Planning Application: Various surgery to 1 No Holm Oak

Reference: **AL/49/17/T**

Location: **Westergate Mews, Nyton Road, Westergate**

Westergate Mews Appendix 5 - survey plan

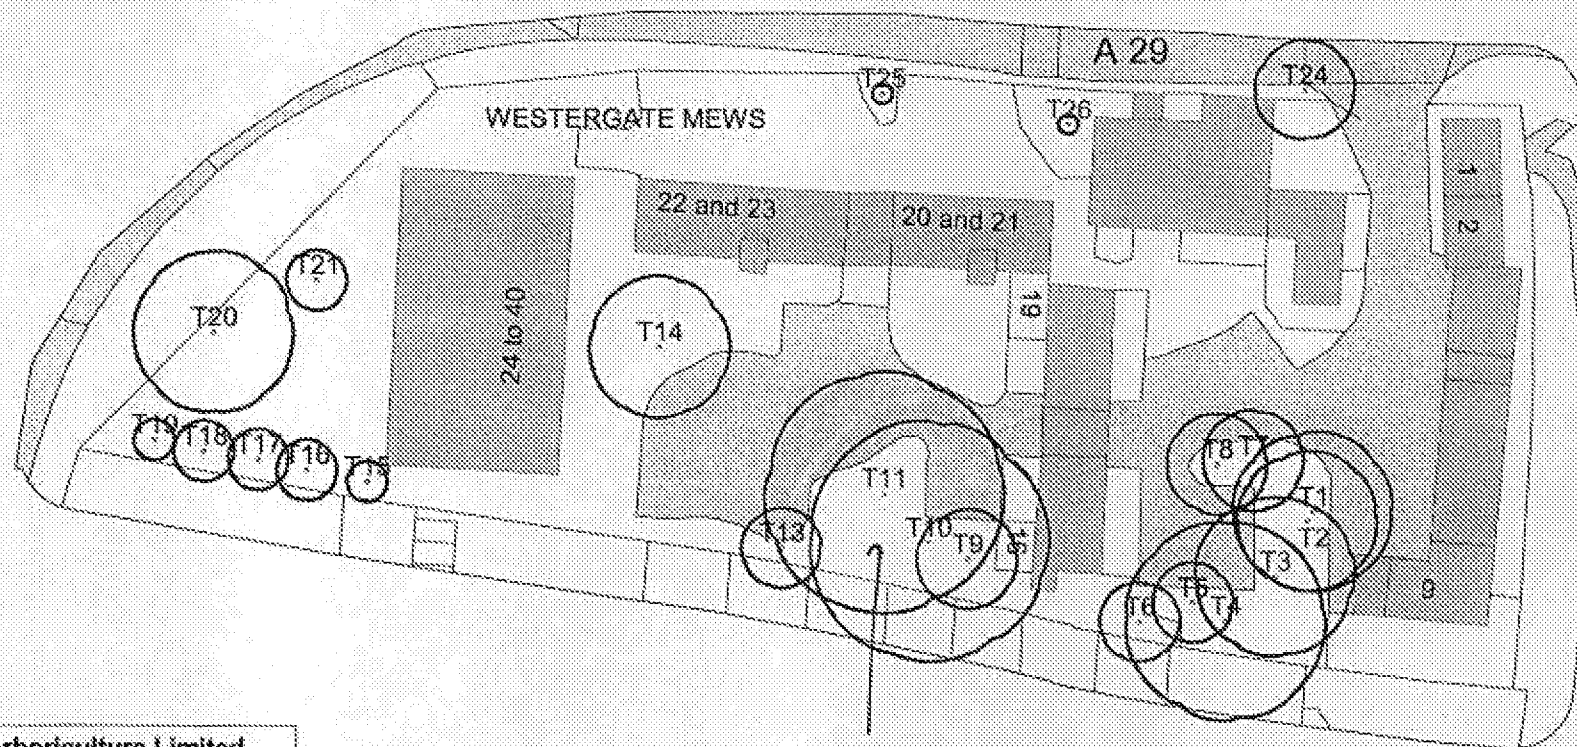
- The applicants have employed Beechdown Arboriculture Ltd to inspect the trees and carrying out a VTA and advising them on a management strategy.
- This is an old mature tree that has undergone many pruning operations in the past including some very heavy topping out work.
- The Holm Oak appears as T11 in this report and I agree with Beechdowns conclusions and recommendations

- The inspection has been thorough and the management strategy well reasoned and I agree with the conclusions and recommendations made in the Beechdown report – inclusive of the insertion of a non-invasive dynamic cable brace.

- I recommend **APPROVAL** for the works as listed in the Beechdown report namely :-
 1. Remove the tips of small diameter, low, hanging branches (dropper branches from larger diameter limbs) to raise the canopy and leave a 4m ground clearance.
 2. Reduce the tips of multi-stemmed regrowth from old pollard points on the southern stem by 1m to 1.5m with cuts no larger than 65mm diameter being formed.
